Major Project: Weigall Sports Complex, Sydney Grammar School

Application Number SSD-10421

We, the undersigned, strongly oppose the application for development works at Weigall Sports Complex in its current proposed form ("submission").

The substation is located near the project boundary off Neild Avenue shown in red hatch.

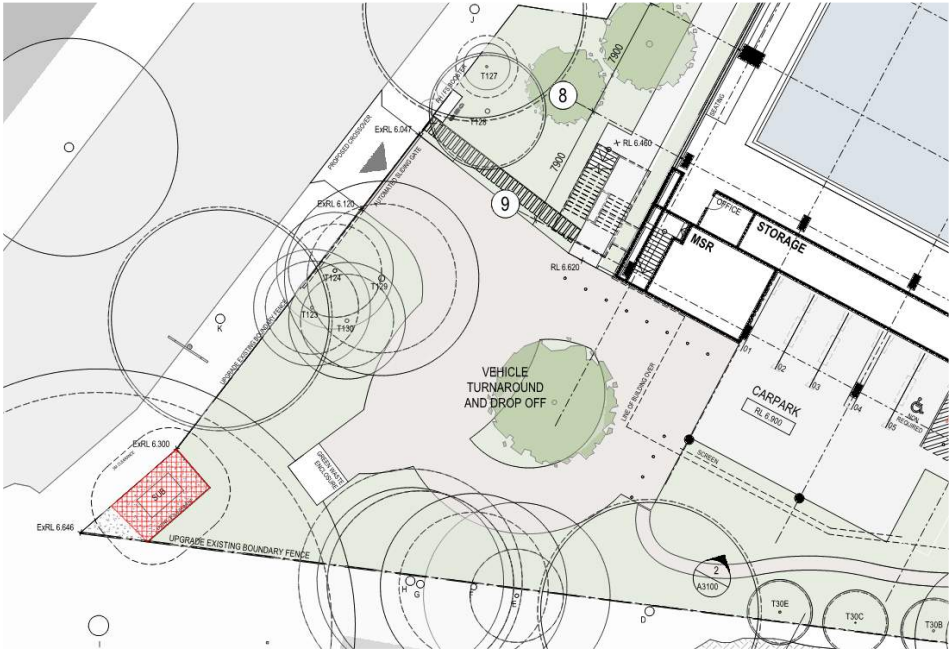
The erection of an electrical substation along the border of Neild Ave/Lawson St poses an unacceptable visual impact on the local area. The submission does not adequately outline what alternative locations or power sources were considered and why these were rejected. An electrical substation will present a visual eyesore in the leafy neighbourhood and devalue nearby homes.

Any electrical substation should be placed away from neighbour's homes to adequately address health concerns associated with electric and magnetic fields emitted from the proposed high voltage substation.
